File Ref. No: BFS16/775 (10351)
TRIM Doc. No: D16/43000
Contact: Arthur Brown

24 May 2016

**Wetherill Park Resource Recovery Facility (SSD 7267)
Wetherill Park**

TITLE  
**PROJECT CONCEPTUAL LAYOUT**

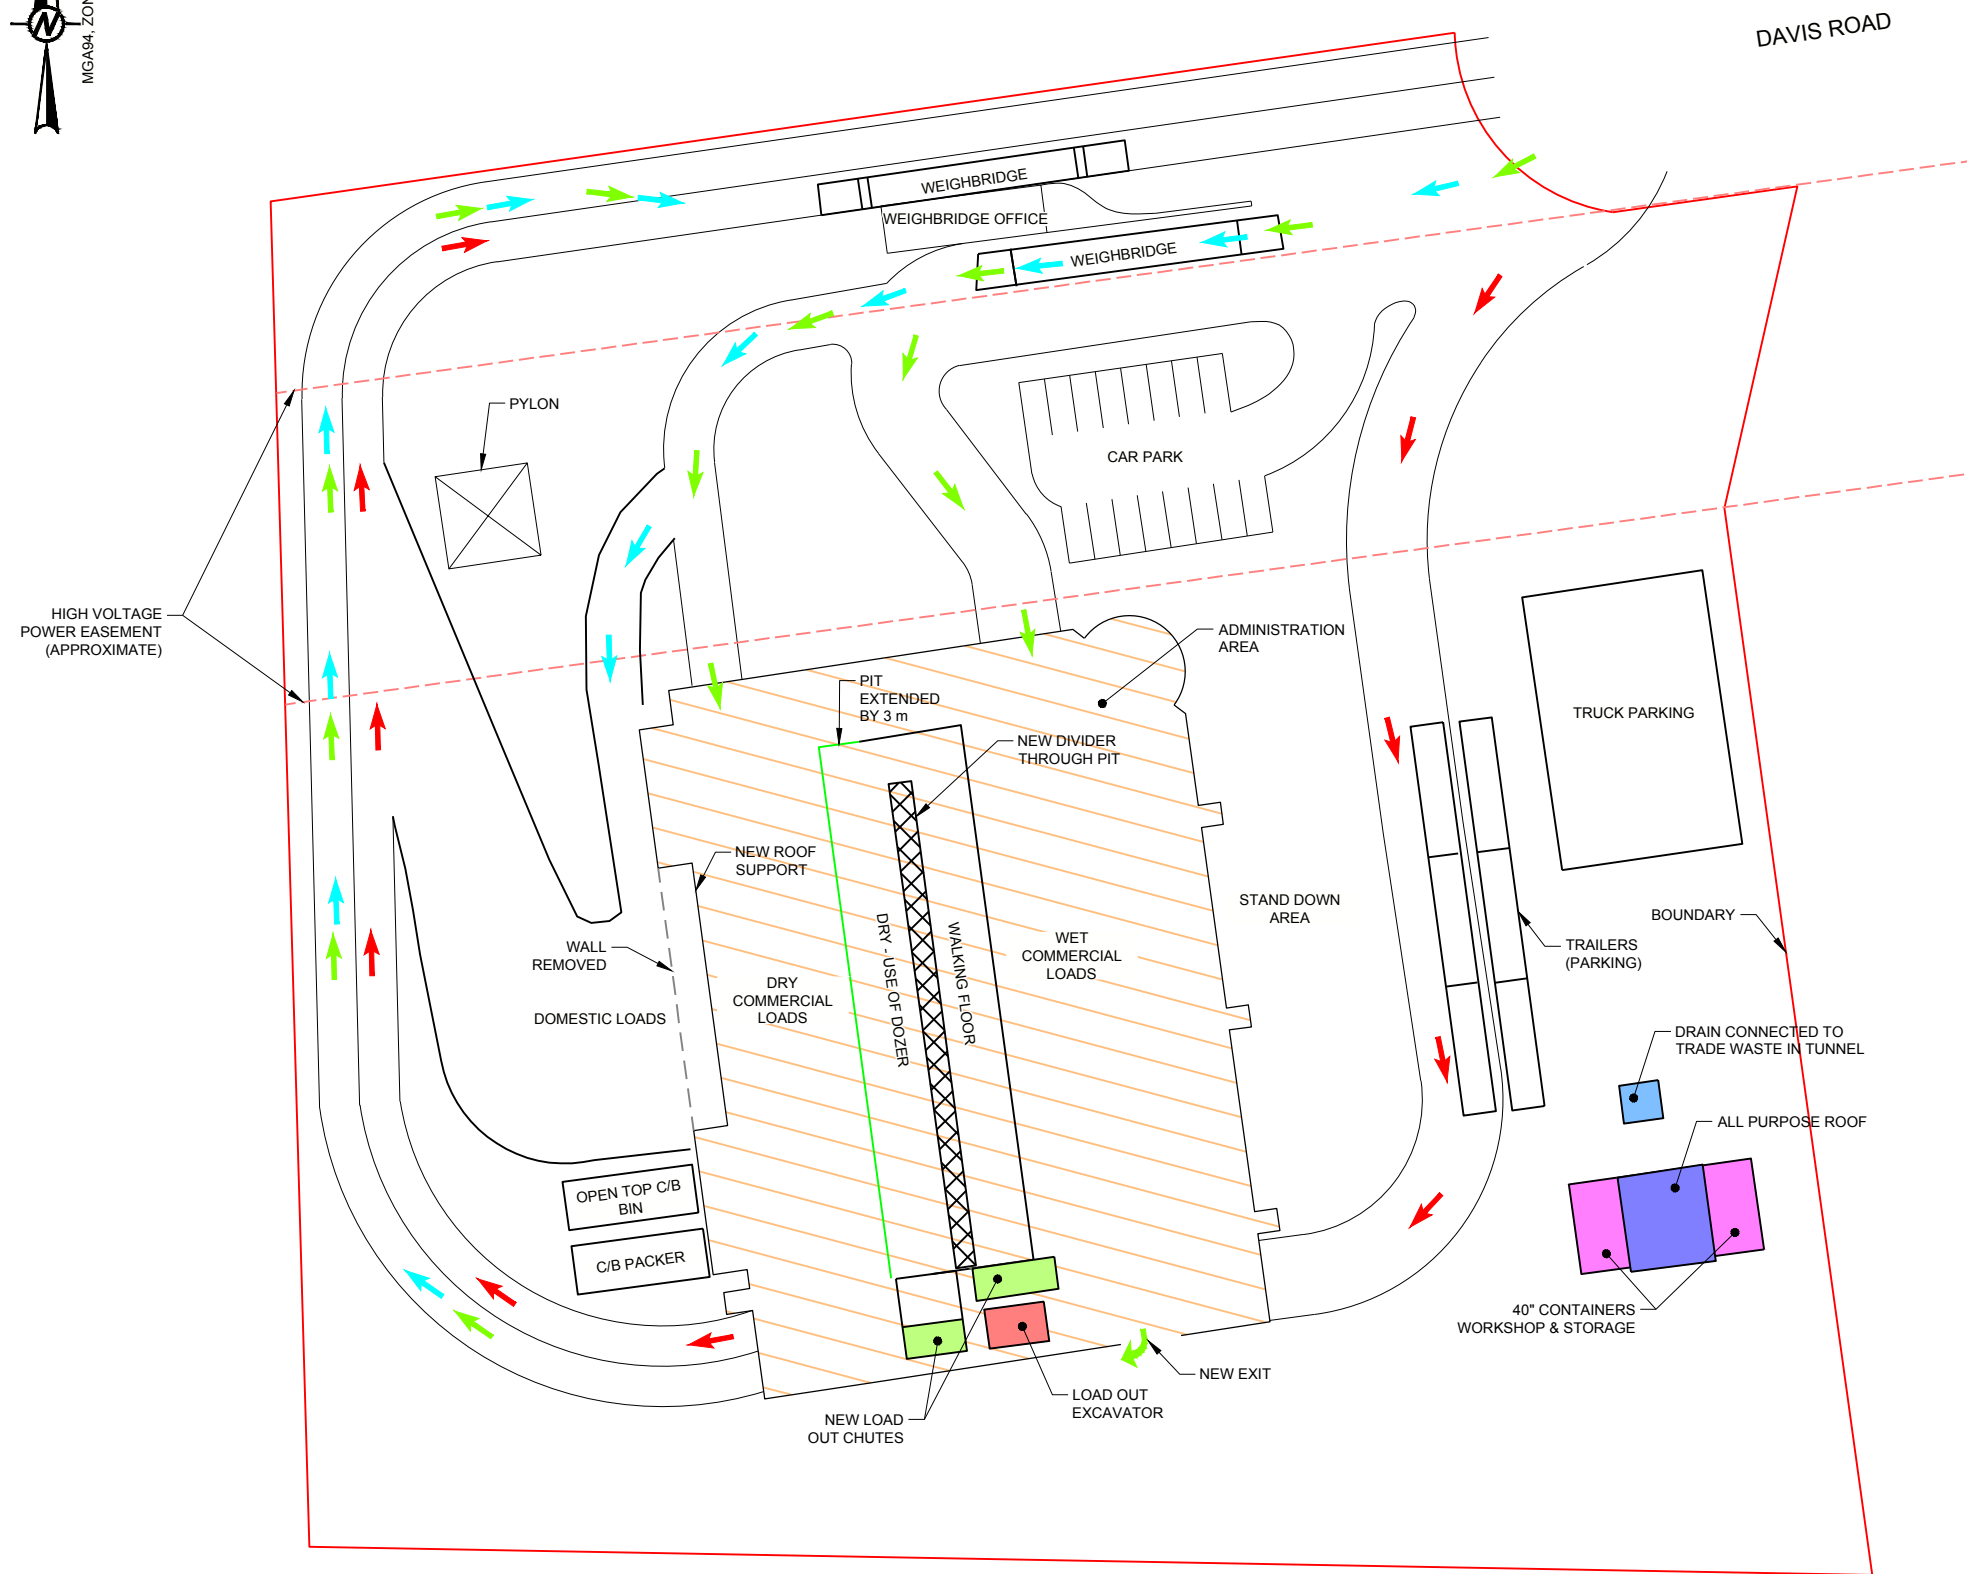
2. Due to the increase in size of the collection area, the existing sprinkler system is also recommended to be extended so that coverage of the entire proposed surge pit and new load out chutes is achieved.
